Application Ref:	3/2019/1103	 Ribble Valley Borough Council www.ribblevalley.gov.uk
Date Inspected:	16 th October 2020	
Officer:	LE	
DELEGATED ITEM FILE REPORT:		Decision

Development Description:	Demolition of existing house and erection of two two-storey detached dwellings with attached garages.
Site Address/Location:	Twin Brook Farm Up Brooks Clitheroe BB7 1P

PROPOSED PLANS AND ELEVATIONS BUILDING 2			
Site: Twin Brooks Farm Upbrooks Clitheroe			
Client: Mr M Alpe			
Date: 02.10.19		Scale: 1:100 @ A2	
Project No: MALPE/01 Dwg 06		Drawn: AxK	
Amendments:

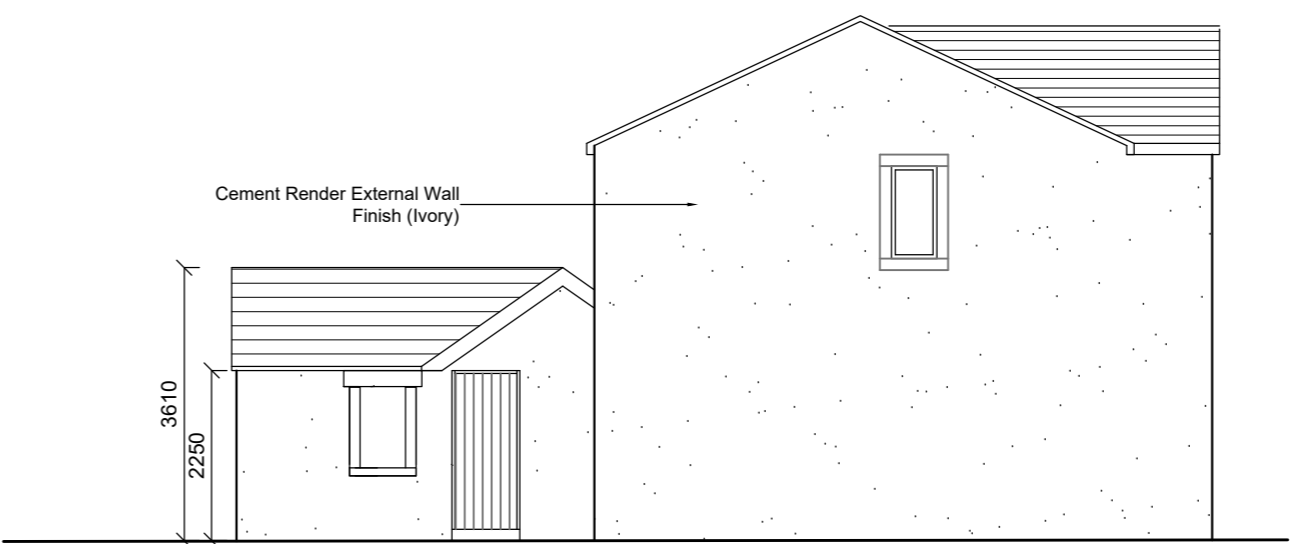
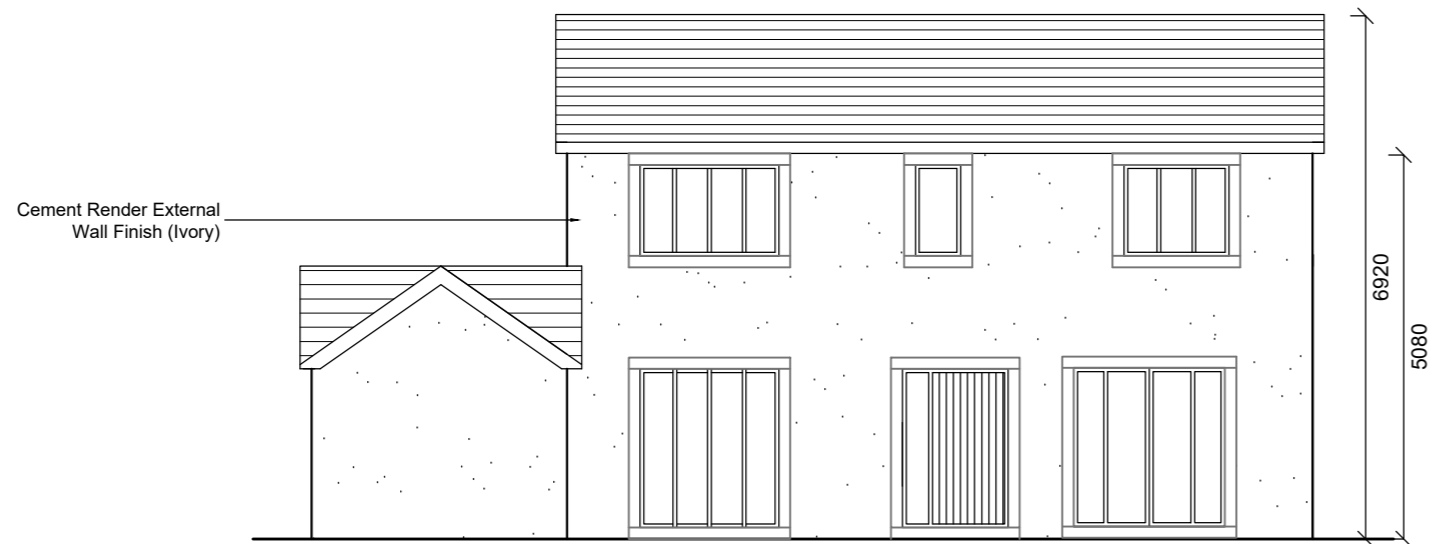
The replacement dwelling (building 2) will be detached and the application states that the dividing wall will be made good. The existing height of the farm and barn is 6715mm. The new dwelling will be slightly higher at 7718. It has a forward projecting gable which will be in line with the recessed part of the barn where there is full height glazing and the main portion of the new dwelling will be set further back. There will be a gap of approx. 1 metre to the side boundary. It will have an impact visually by changing the relationship between the formerly attached farm and barn. The new dwelling will be of a simple form constructed of traditional materials. Given the location, loss of character and surrounding development it is not considered that this impact will be harmful providing that the exposed gable wall to the barn is made good with suitable materials and the choice of materials for the new dwelling is acceptable.

PROPOSED PLANS AND ELEVATIONS BUILDING 1					
Site: Twin Brooks Farm Upbrooks Clitheroe					
Client: Mr M Alpe					
Date: 02.10.19			Scale: 1:100 @ A2		
Project No: MALPE/01 Dwg 05				Drawn: AxK	
Amendments:

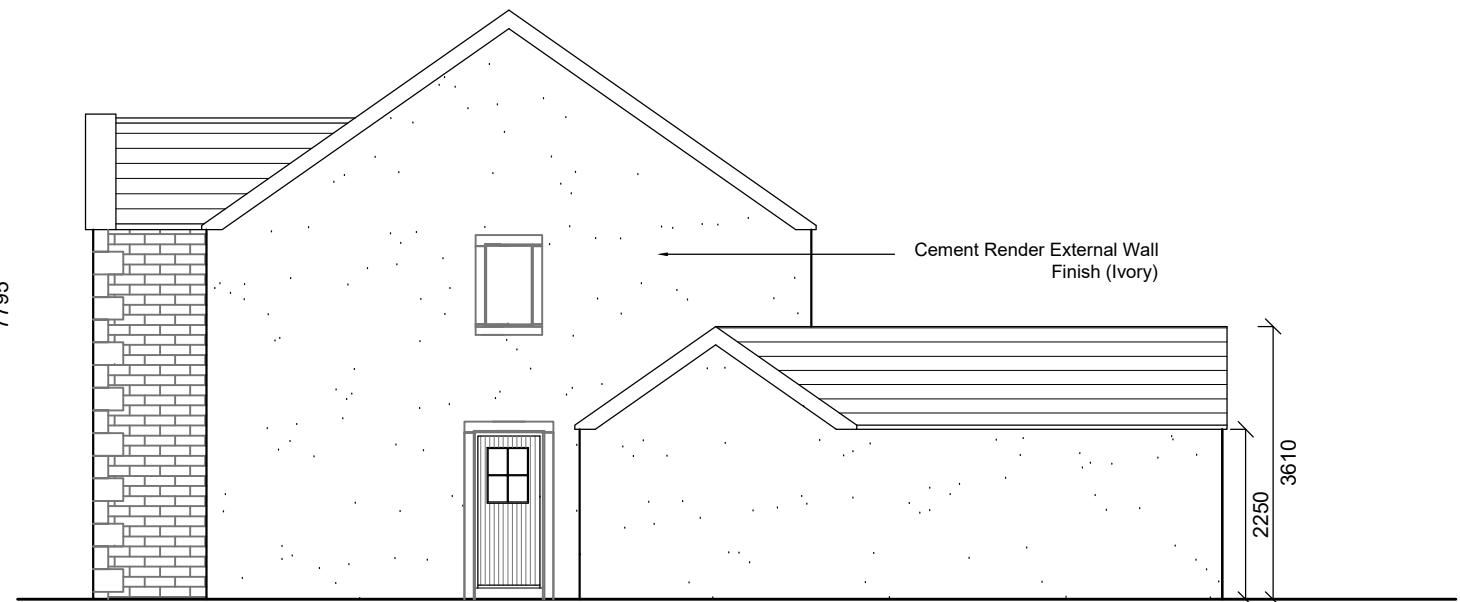
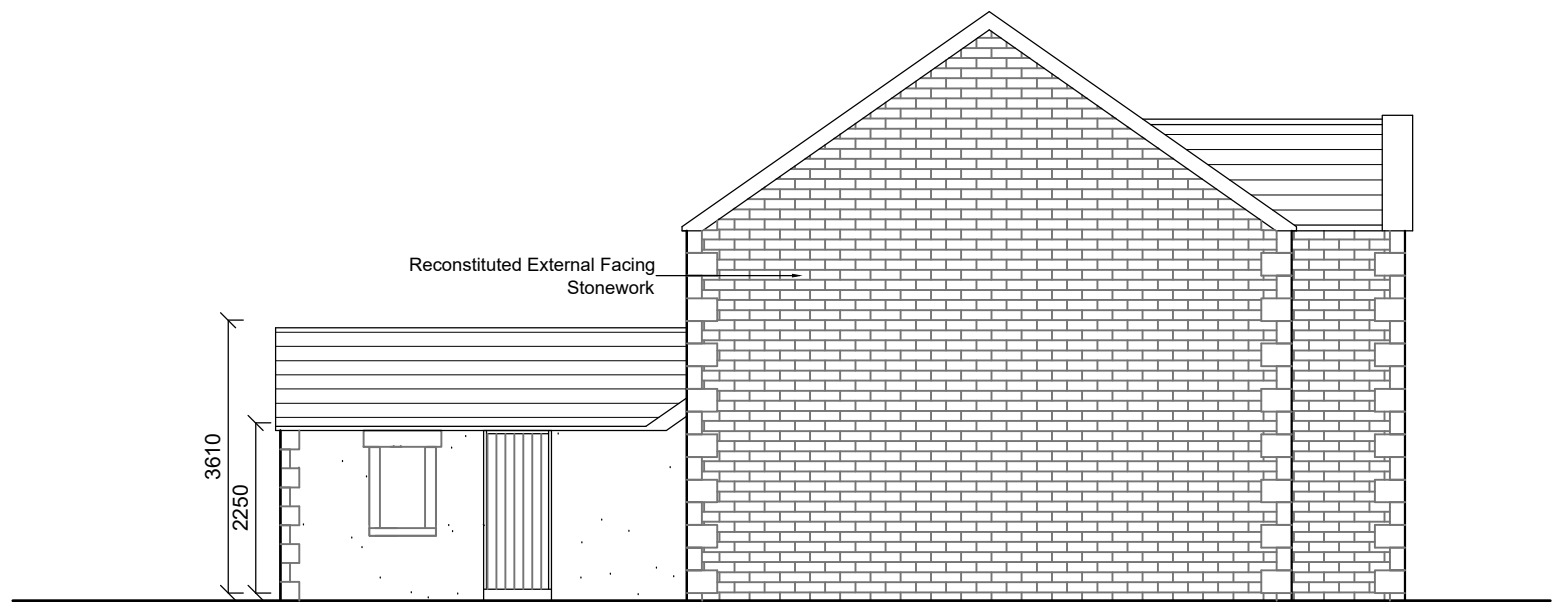
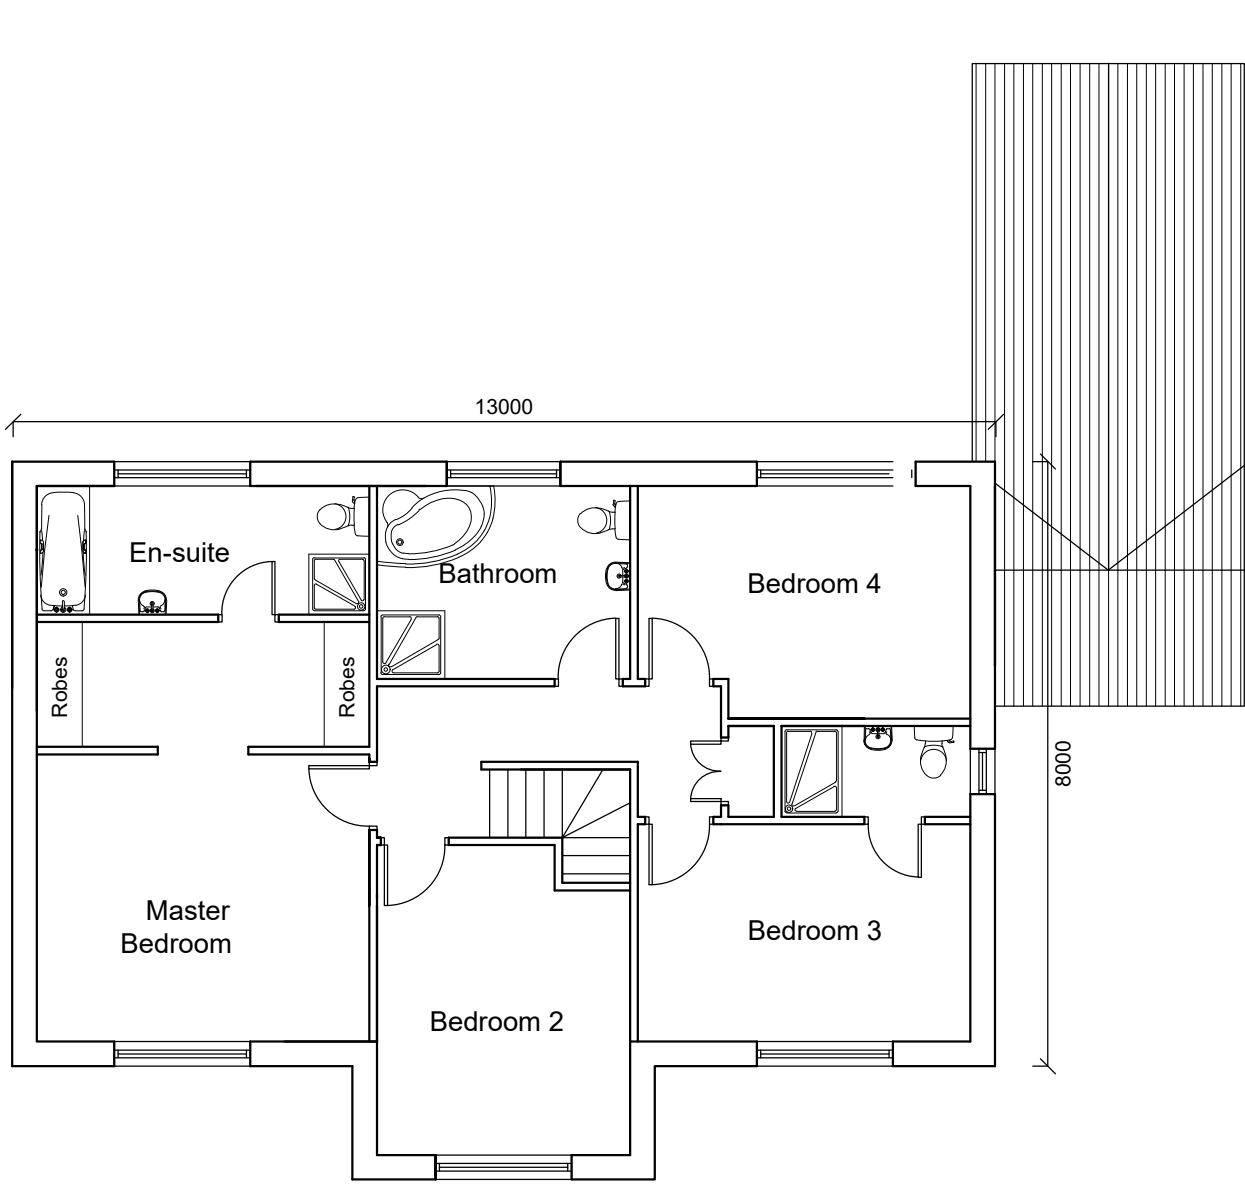
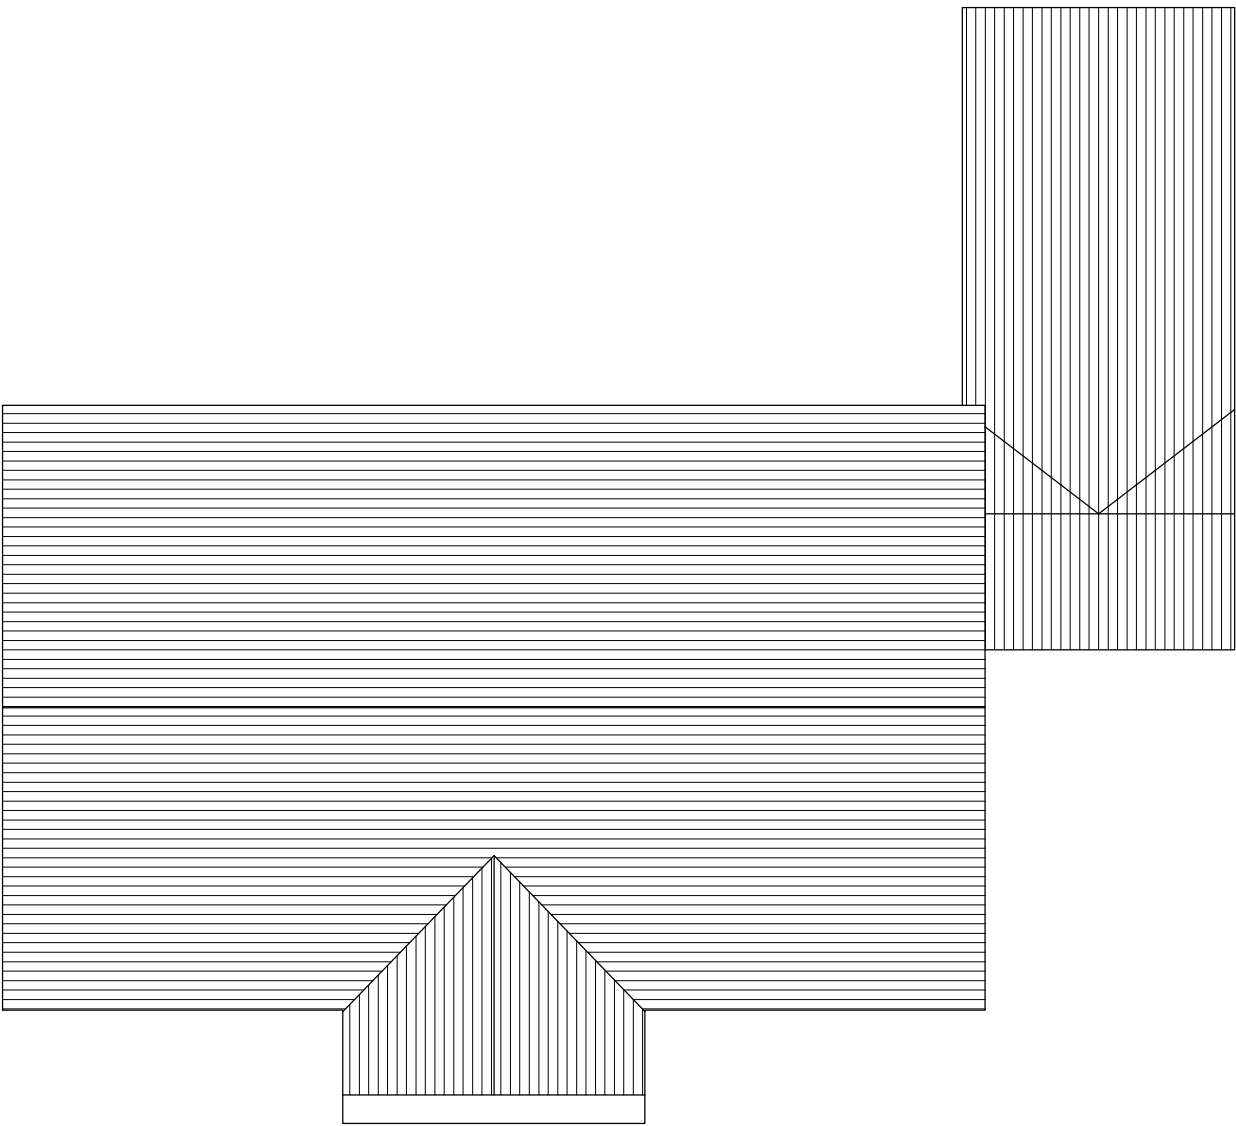
Building one is located to the rear of the site and is oriented so that the rear elevation faces onto to the barn's garden. There is a distance of 9.5 metres to the common boundary. Amended plans have been received which omit a bedroom window from rear elevation, there are two windows at first floor which serve bathrooms and a condition can be imposed to ensure that these remain obscure glazed in perpetuity. Whilst it will introduce substantial built form into the former garden and change the outlook from the neighbouring house, it is considered that the distance to the boundary and location of windows facing away from the neighbour will mitigate any harmful impact.
